Transport Assessment

State Significant Development Application – Modification

657-769 Mamre Road, Kemps Creek (SSD-9522) Modification

TABLE 2 RESPONSE TO TFNSW COMMENTS – EMAIL OF 3 NOVEMBER 2021

TUNNING PATHS PLAN-LOT 2 ACCESS
SCALE 1:300

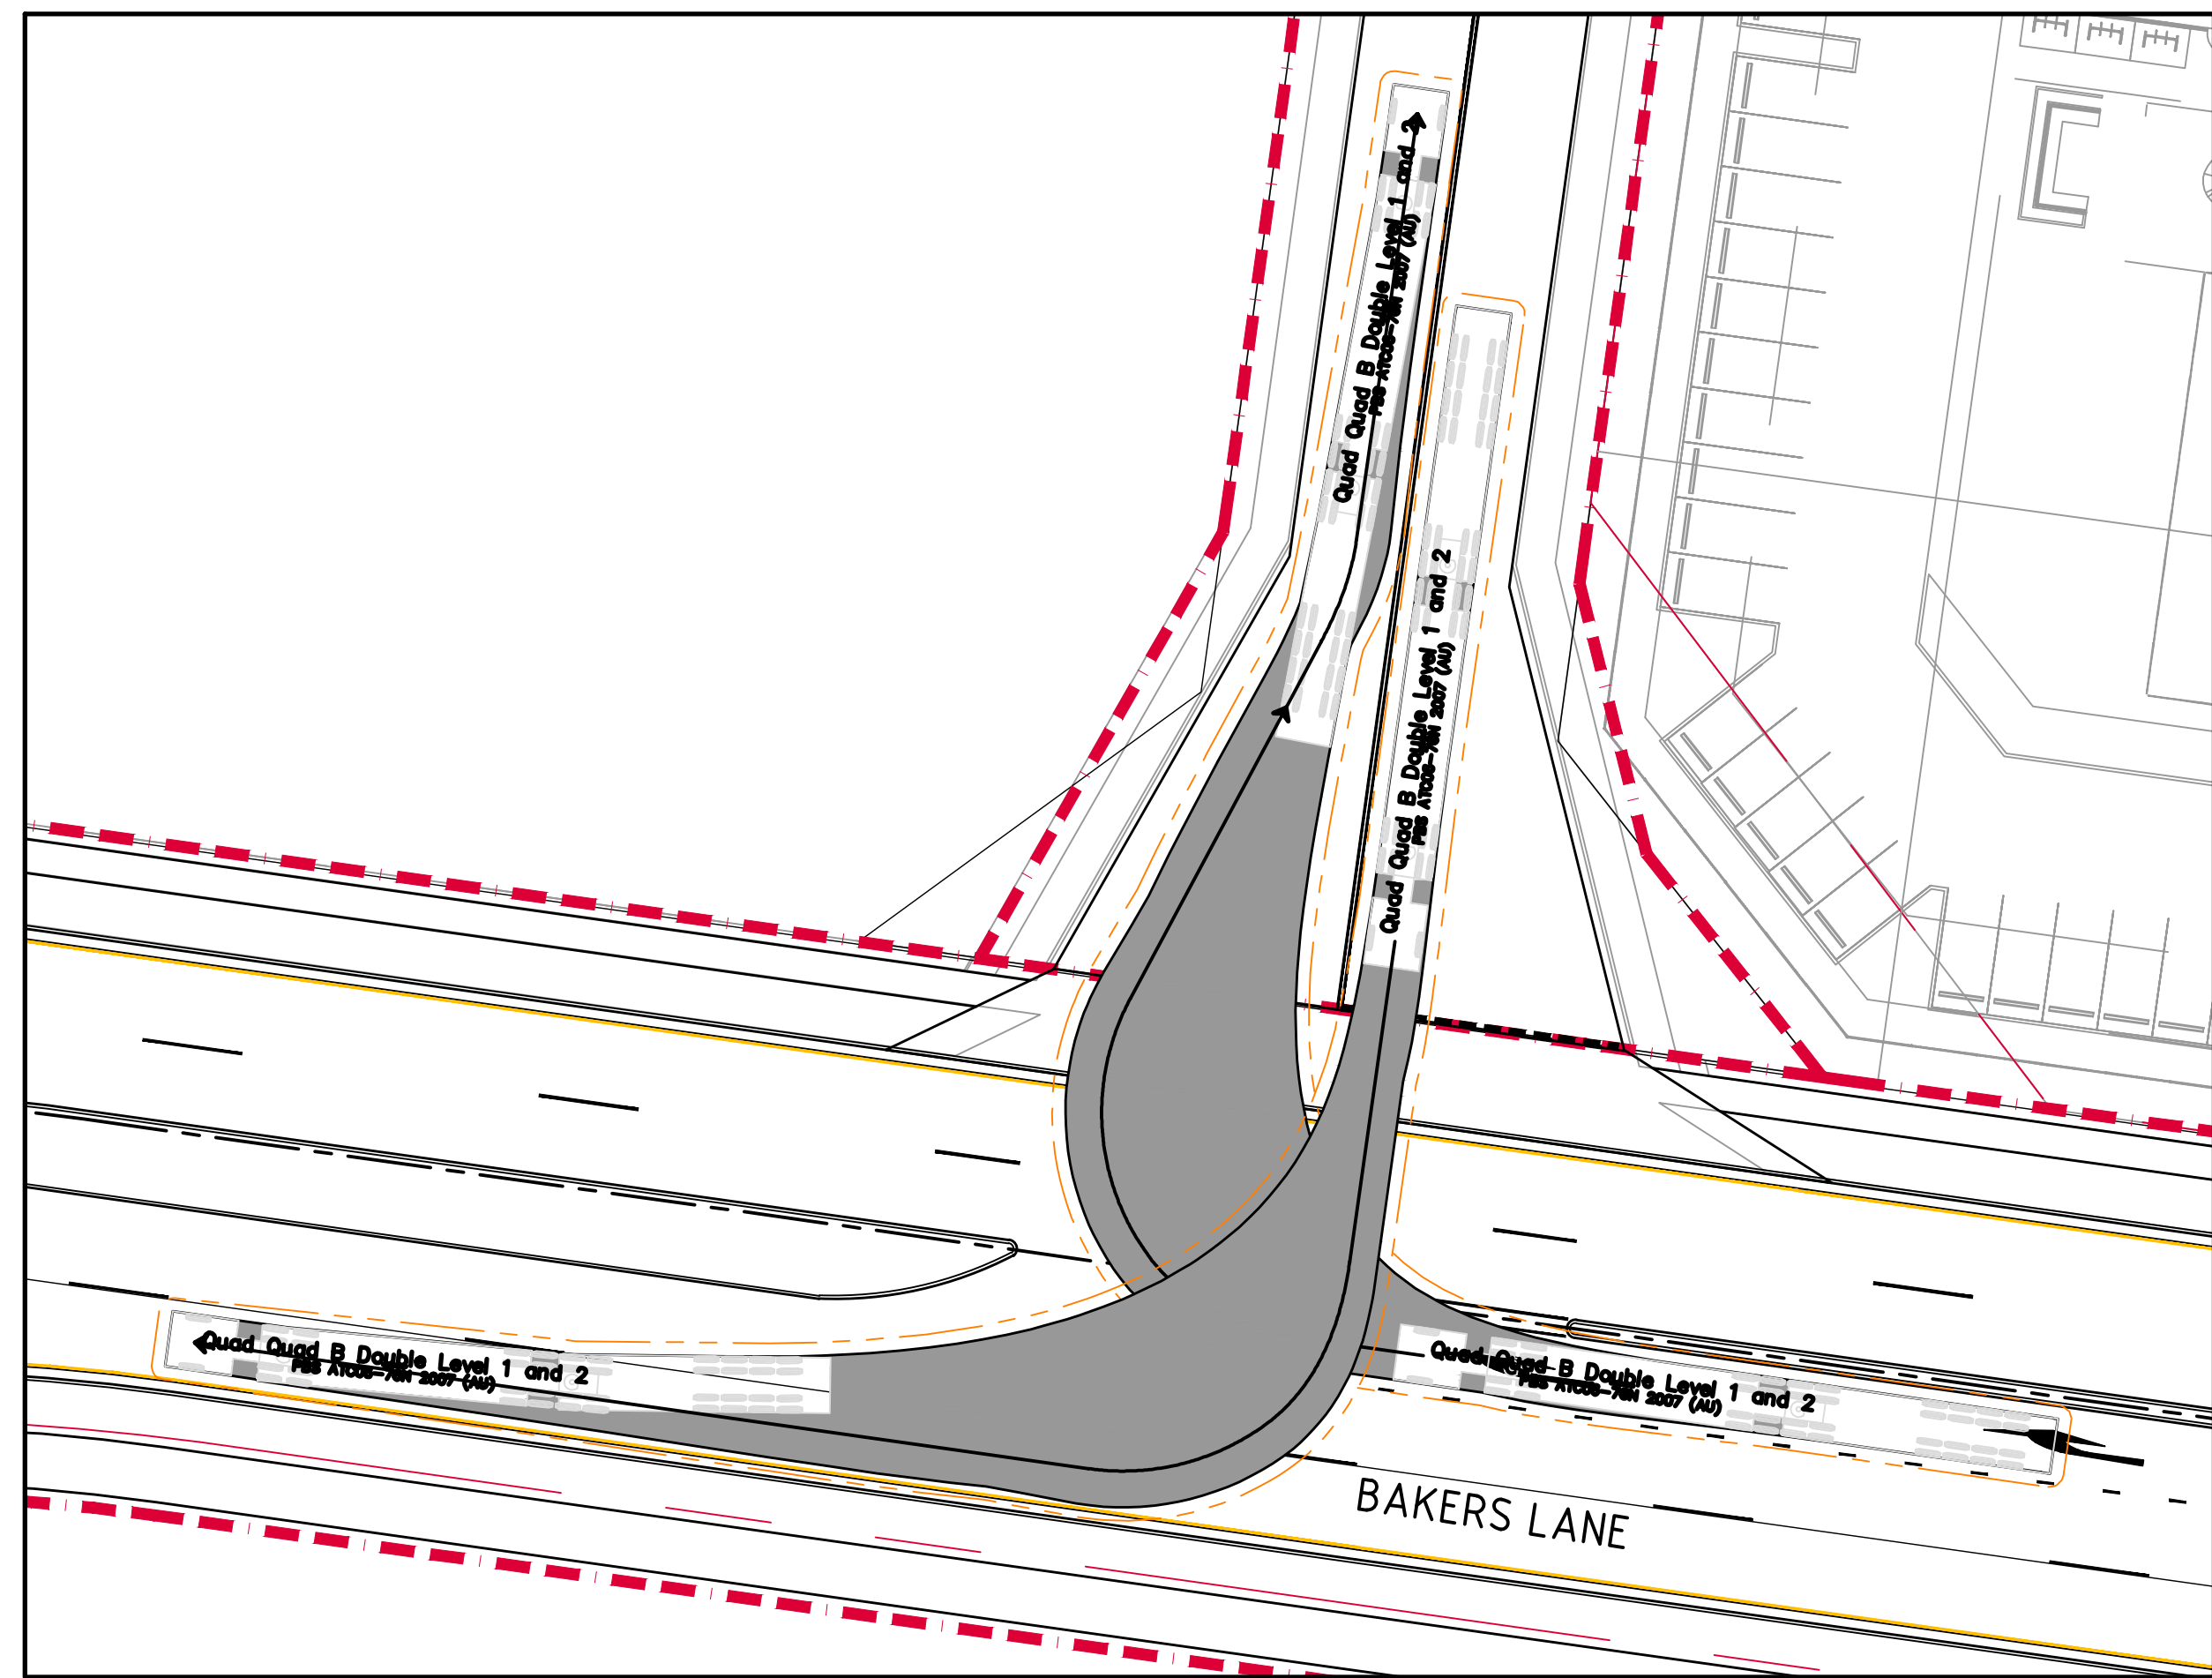
- 3 Access closest to Mamre Road – in order for a 26m B-double to undertake the turn they would need to undertake the turn from the wrong side. Any access to should be able to accommodate for simultaneous entry/exit.

It is important to note that this access point is a heavy vehicle exit point only for Lot 2 (which does NOT ACCOMMODATE ENTRY movements). Therefore, 26.0m B-double trucks will not undertake entry movements for Lot 2 (from this access crossover). Based on the swept path analysis included in **Appendix D**, this exit movement can occur in a lane correct manner. A reduced copy is also re-produced overleaf.
